Technical Note

Project No: ITB16357
Project Title: Land South of A259, Angmering
Title: Transport Assessment Scoping Note
Ref: ITB16357-001
Date: 17 December 2020

From: Stephen Gee <Stephen.Gee@westsussex.gov.uk>
Sent: 14 January 2021 11:24
To: Dominic Smith
Subject: Pre 147 20 Development of circa 76 dwellings at Land south of A259 Angmering.

Pre-147-20
Development of circa 76 dwellings at Land south of A259 Angmering.

Preliminary Design Check – A259 Littlehampton Road / Site Access Priority Junction Left-in / Left-out (Drawing No ITB16357-GA-004 Rev F)

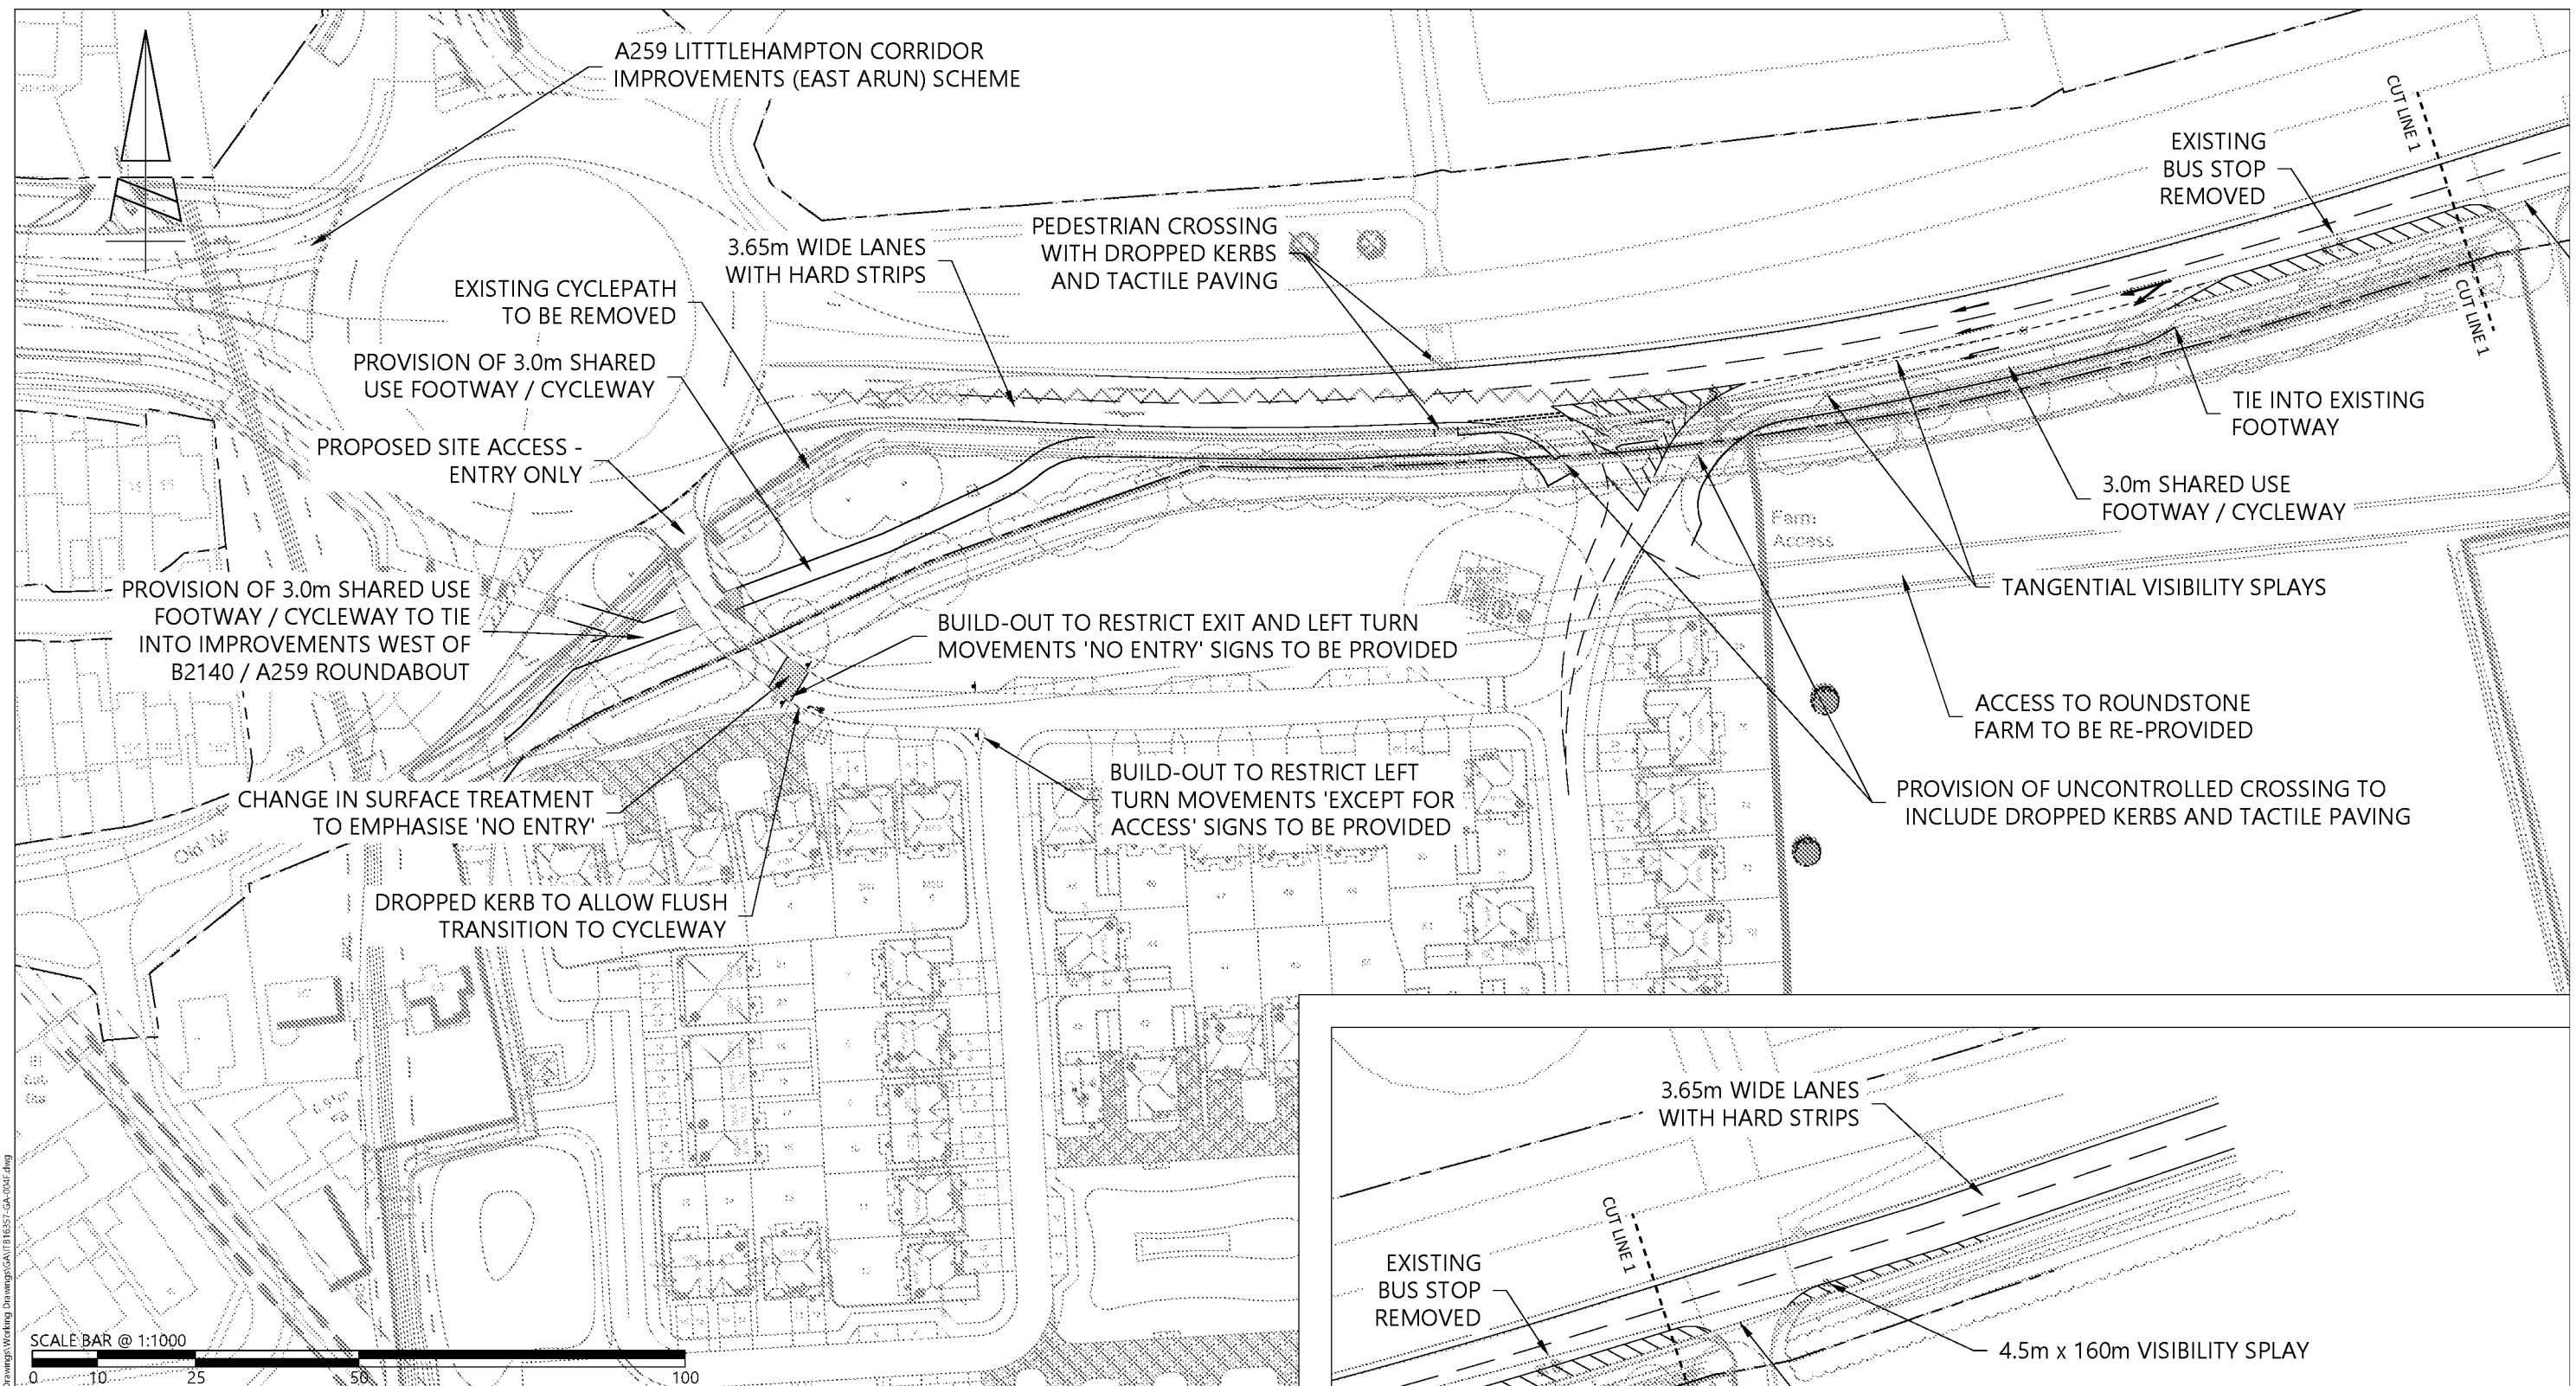
It is proposed to provide an exit only on the A259 J11 and a LILLO on the A259 westbound carriageway. There were proposals for a dedicated left turn lane between A259 Westbound and Old Worthing Road which did not make it into the phase 1 A259 improvement works. The inclusion of the LILLO in the position proposed would prevent such an improvement taking place at any point in the future, as the LILLO access would be too close to the diverge point for the slip lane. If possible, it would be prudent to ensure that future development does not prejudice this improvement coming.

Measures to restrict the entry only to the site from the roundabout maybe required.

A Design Audit and stage 1 RSA and GG119 Appendix F compliant designers' response should support any application.

When considering the close proximity of the bus stop, and whether it can be relocated please note that the A259 scheme is providing a new westbound bus stop in a layby opposite Haskins. A Departure from standard would be required for the bus stop in close proximity to the site access.

Please note the presence of a map type ADS sign adjacent to the slip lane, about 20m west of the start of the taper

The hard strips are required to: ensure that surface water accumulations are clear of the wheel track and support the edge of carriageway. Full lane widths including hard strips may also be required to enable the council to undertake road maintenance activities whilst retaining safe working widths to operatives without the need for road closures.

The loss of hard strips and proposed reduced lane widths are departures from standard, which will require approval prior to their incorporation in a design. In addition to the relevant section of the DMRB relating safe maintenance (GD 304) needs to be given adequate consideration.

There is a PROW crossing point of the A259 in the vicinity of the LILLO which has not been given adequate consideration in the design.
